East Anglia ONE North and East Anglia TWO Offshore Windfarms

Applicants' Comments on Suffolk County Council's Deadline 12 Submissions

Applicant: East Anglia TWO and East Anglia ONE North Limited
Document Reference: ExA.AS-5.D13.V1
SPR Reference: EA1N_EA2-DWF-ENV-REP-IBR-001141

Date: 5th July 2021
Revision: Version 01
Author: Royal HaskoningDHV

Appendix 5: Plan and Cross Sections of Indicative SuDS Basins

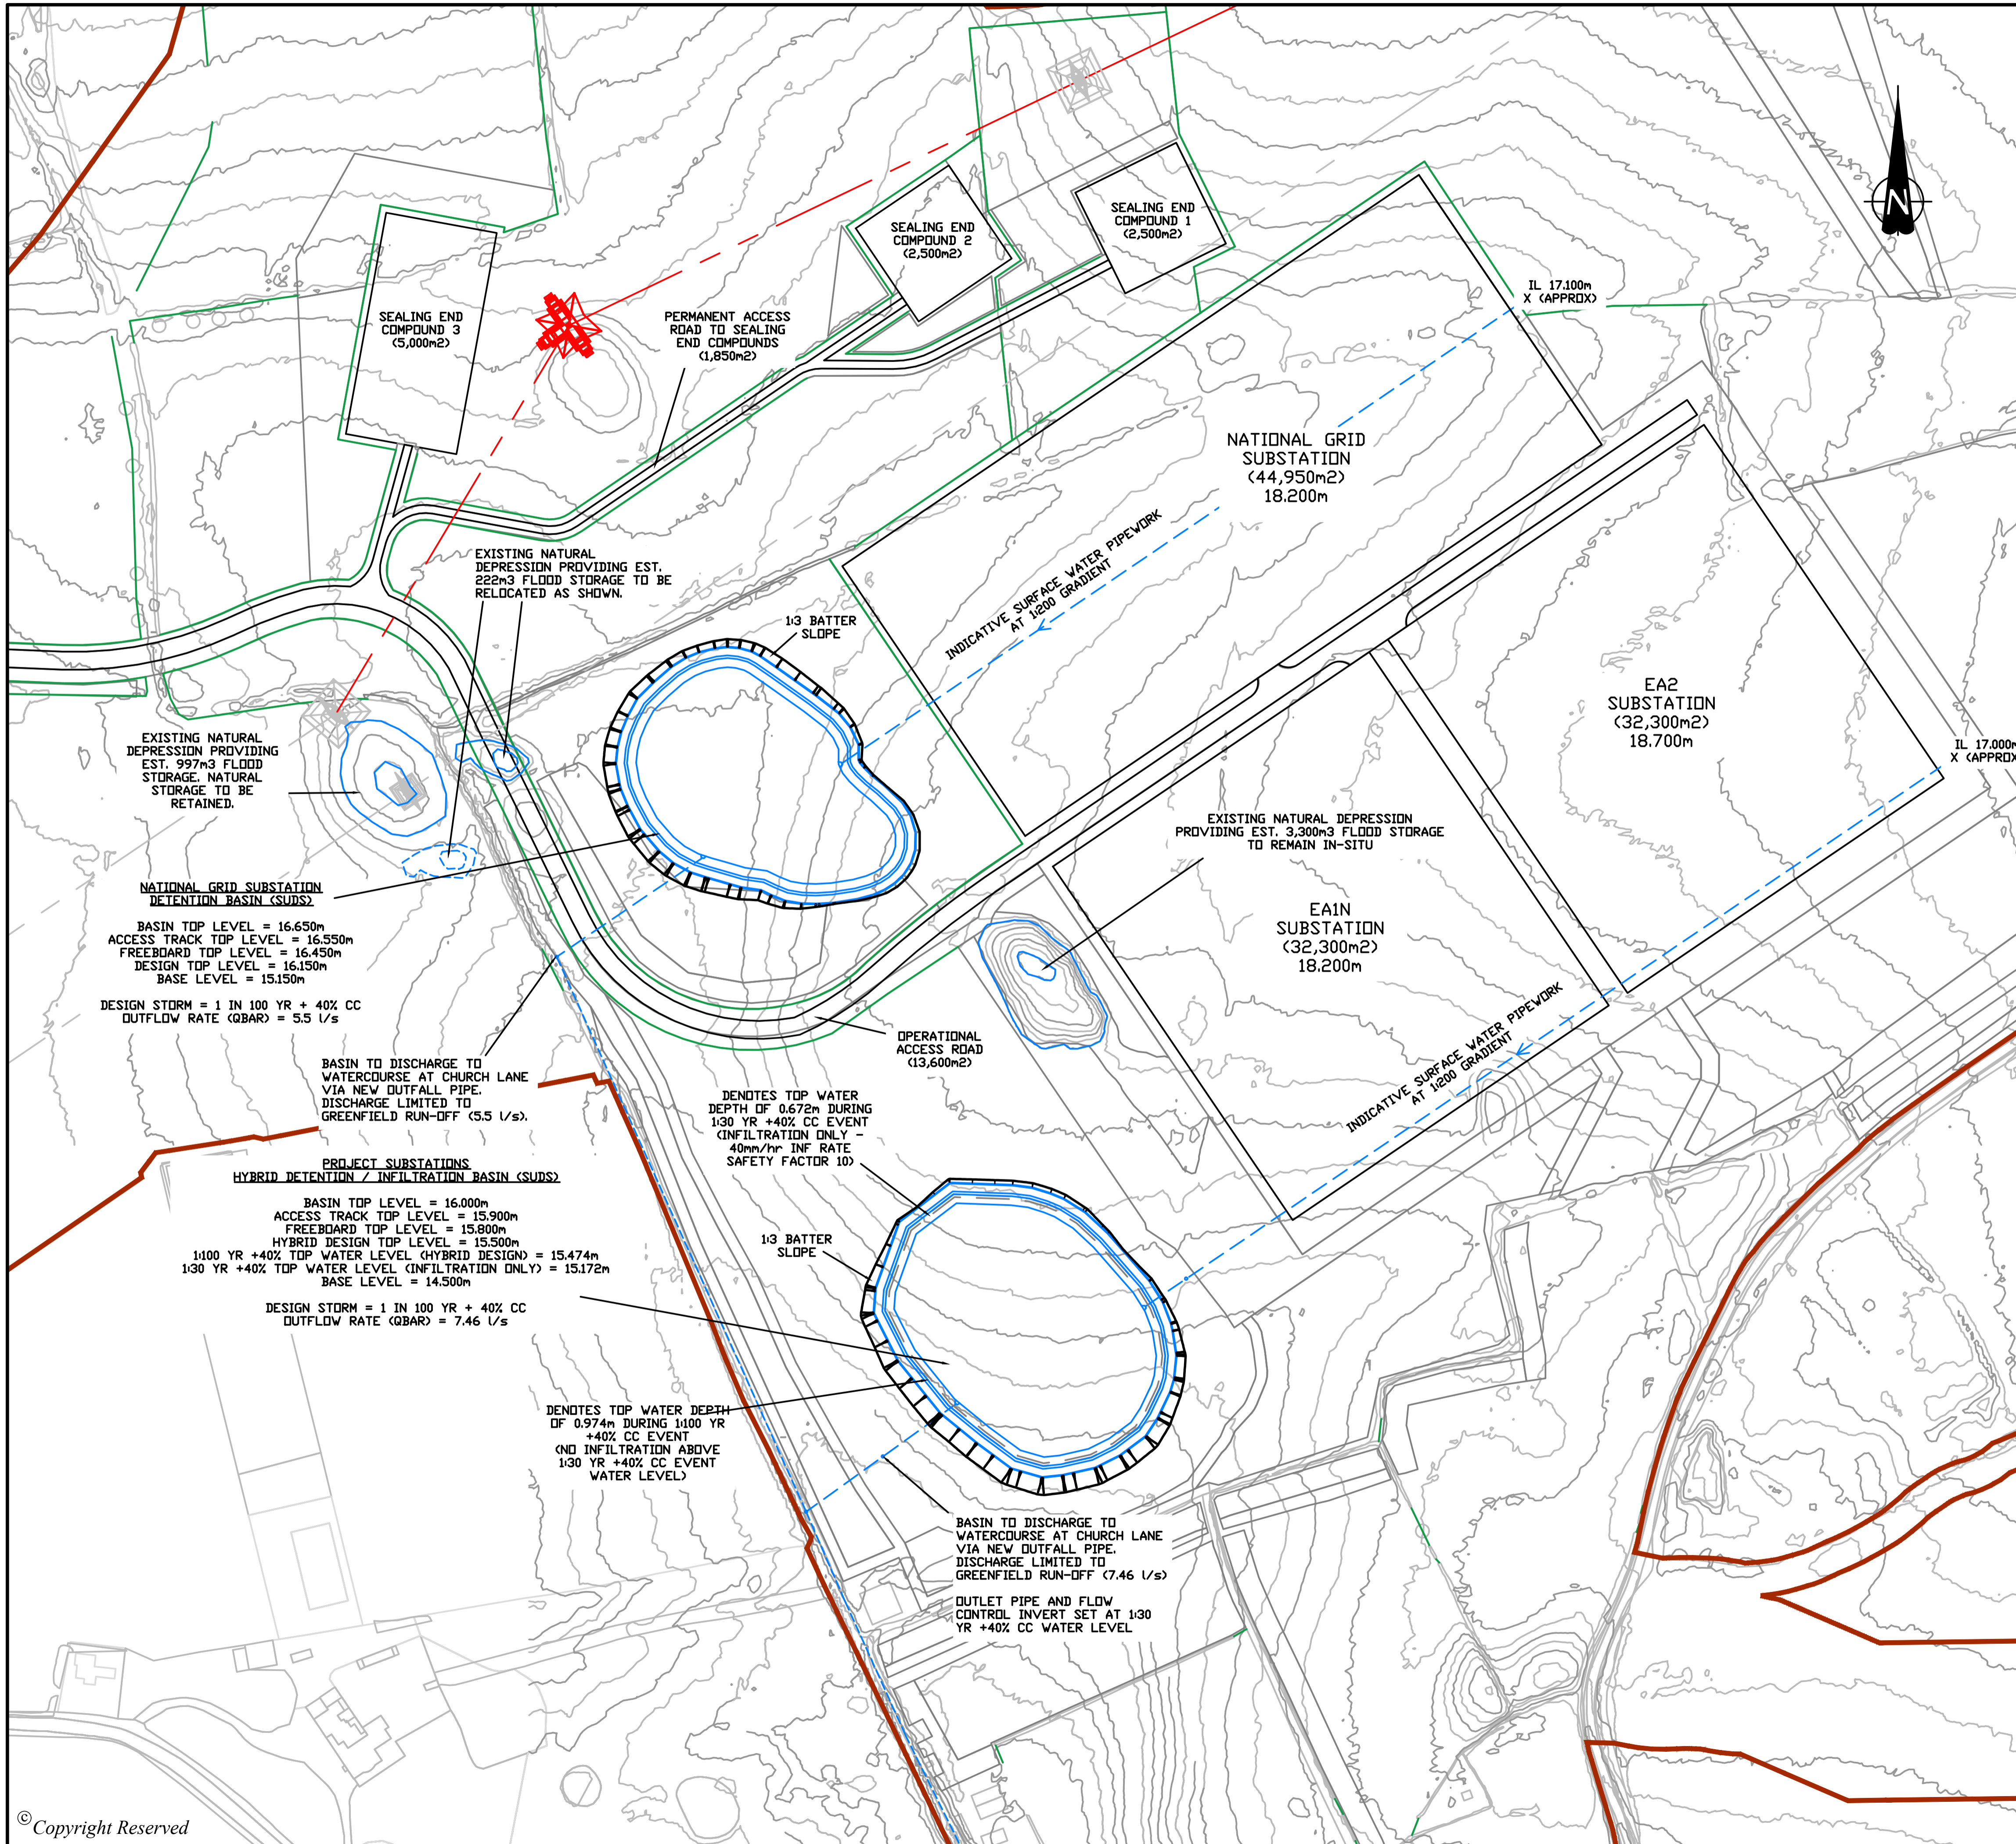
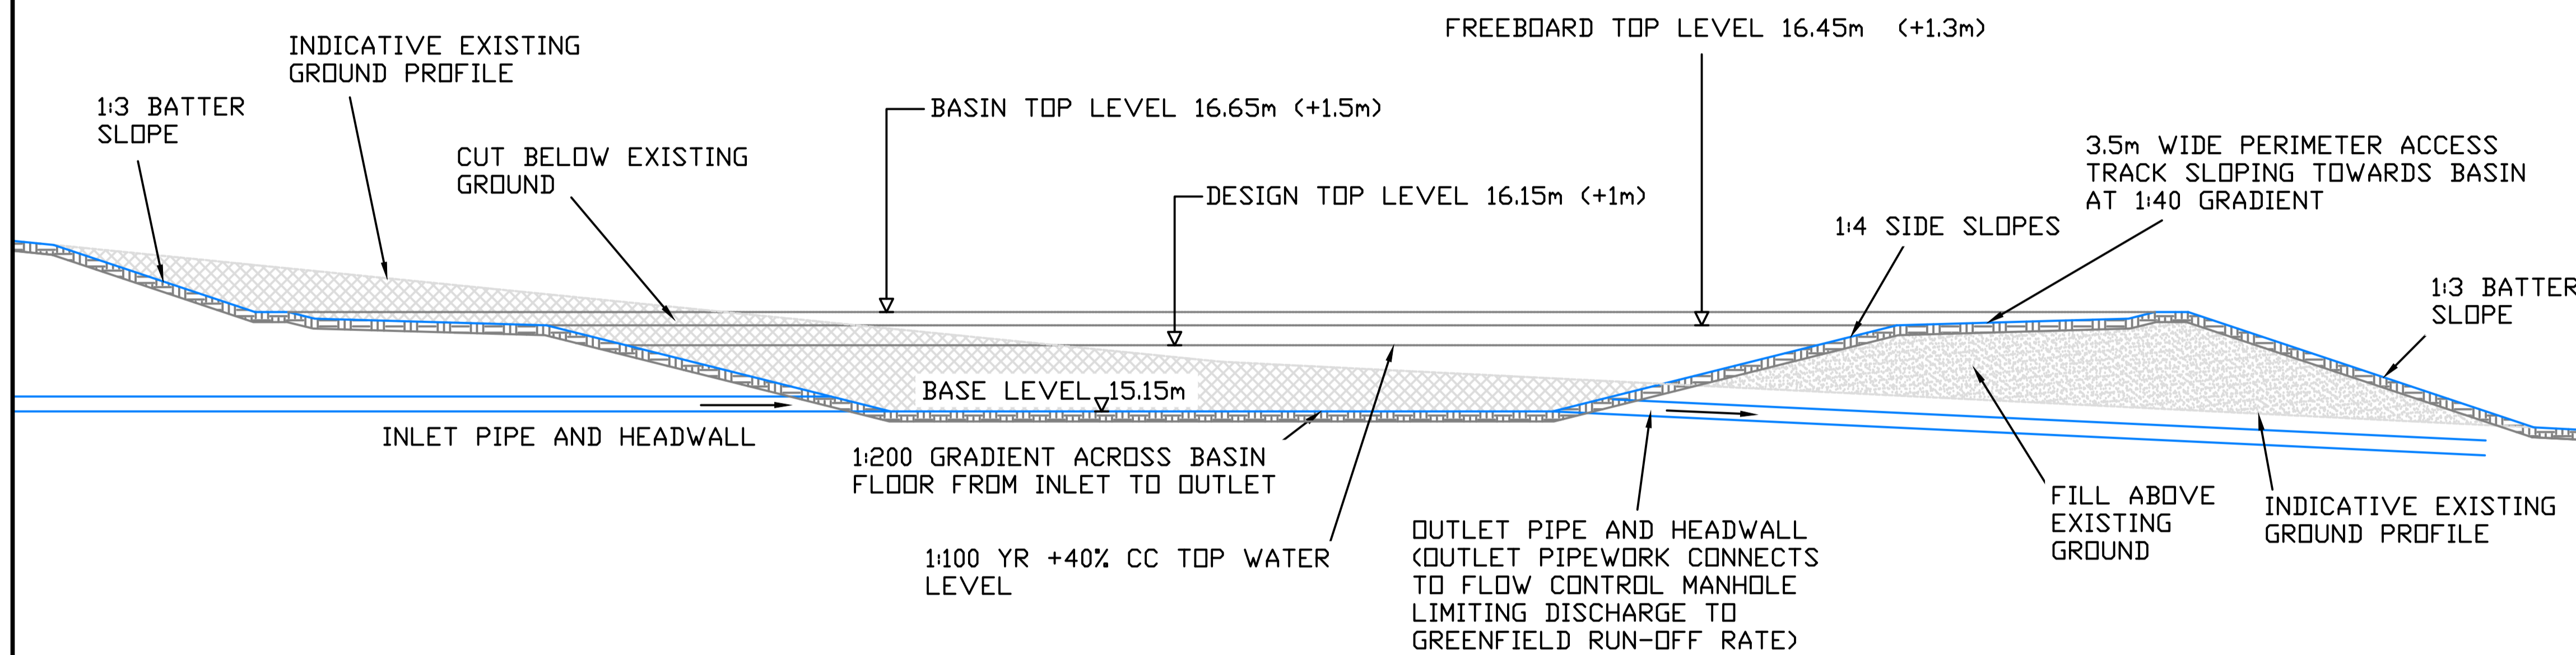
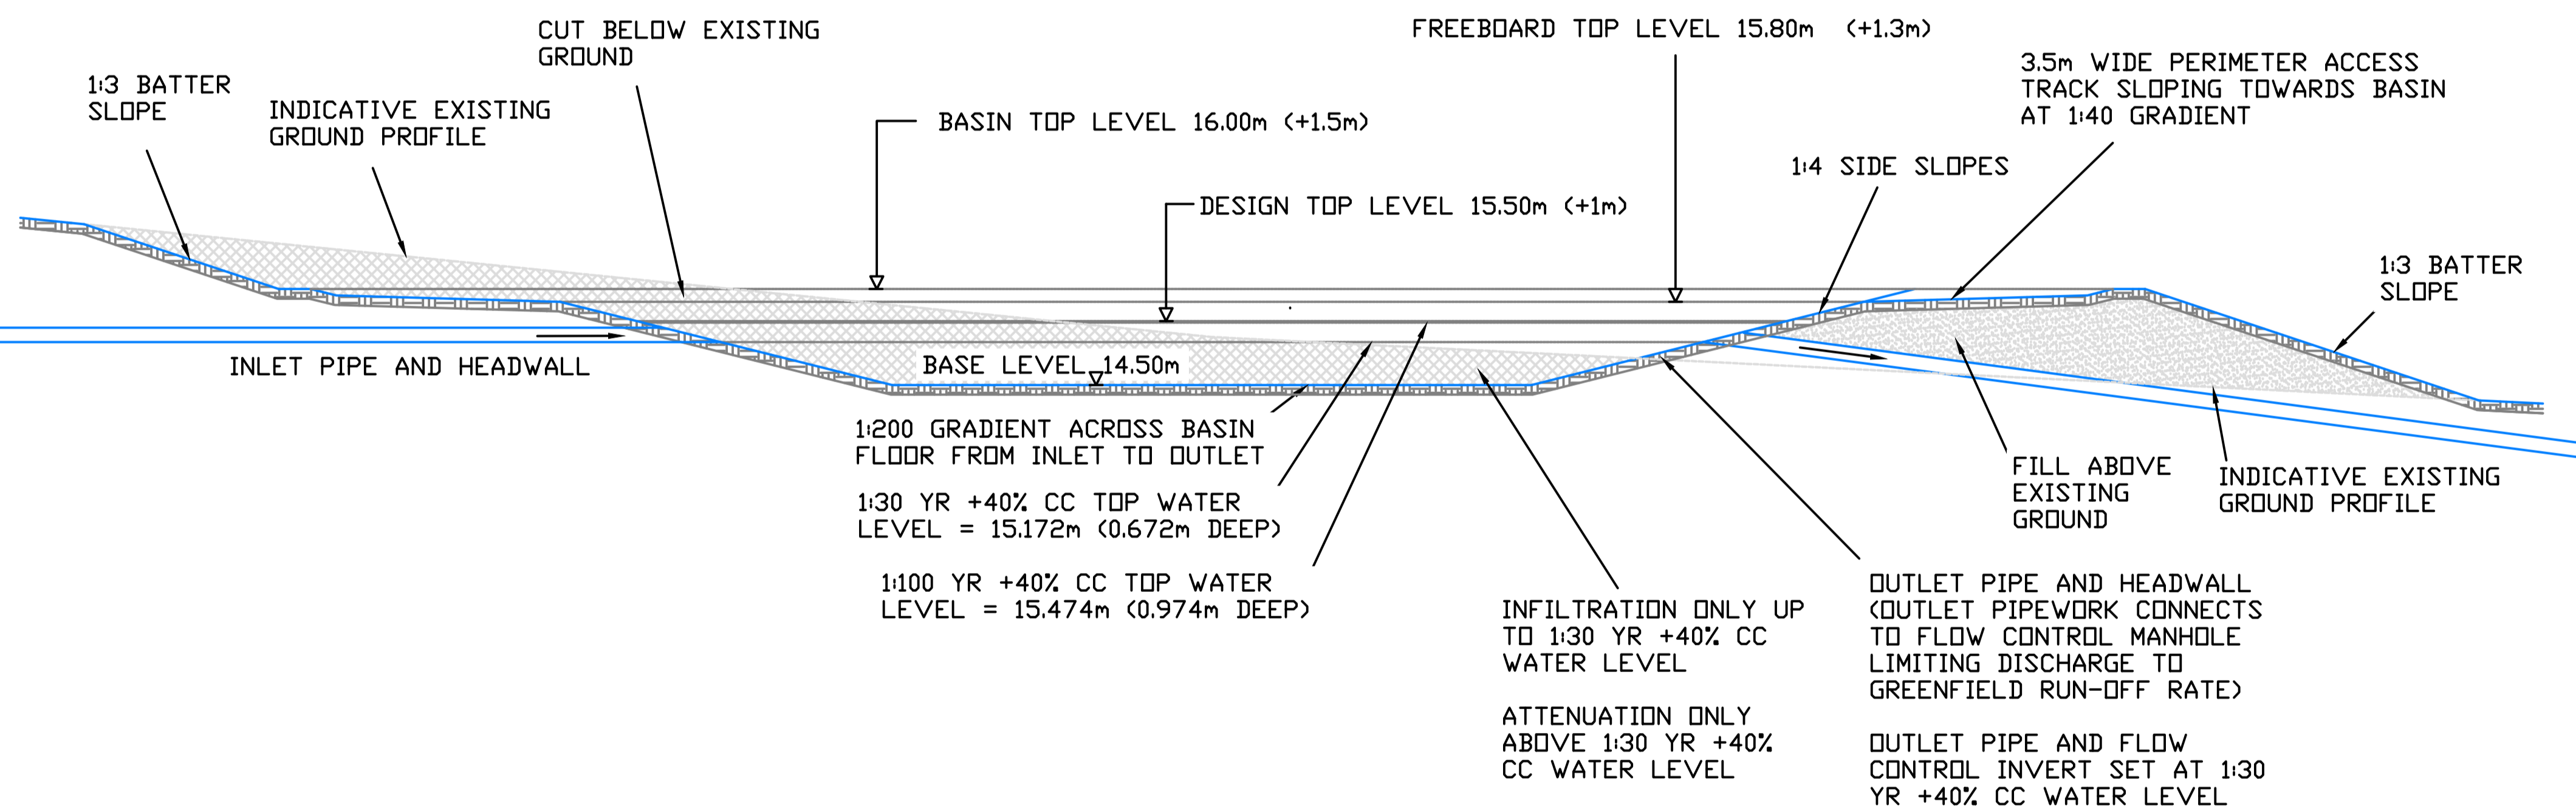
14	Appendix 5	Revised location of existing natural depression is acceptable to SCC	The Applicants welcome SCC's agreement on this matter.
15	=	<p><u>Summary</u></p> <p>The OODMP submitted after Deadline 11 (AS-125) is generally agreeable to SCC, although we would encourage the Applicant to consider the points raised by SCC above and provide us with informal comments/additional information where requested, prior to Deadline 13. SCC would</p>	<p>The Applicants welcome SCC's agreement on and input to the OODMP submitted at Deadline 12 (REP12-057).</p> <p>Regarding accommodation of an additional '1:10+CC' rainfall event after 24 hours where half drain times exceed 24 hours, the Applicants note that drainage calculations would highlight the half drain time for a hybrid system. If the issue is not apparent in the</p>
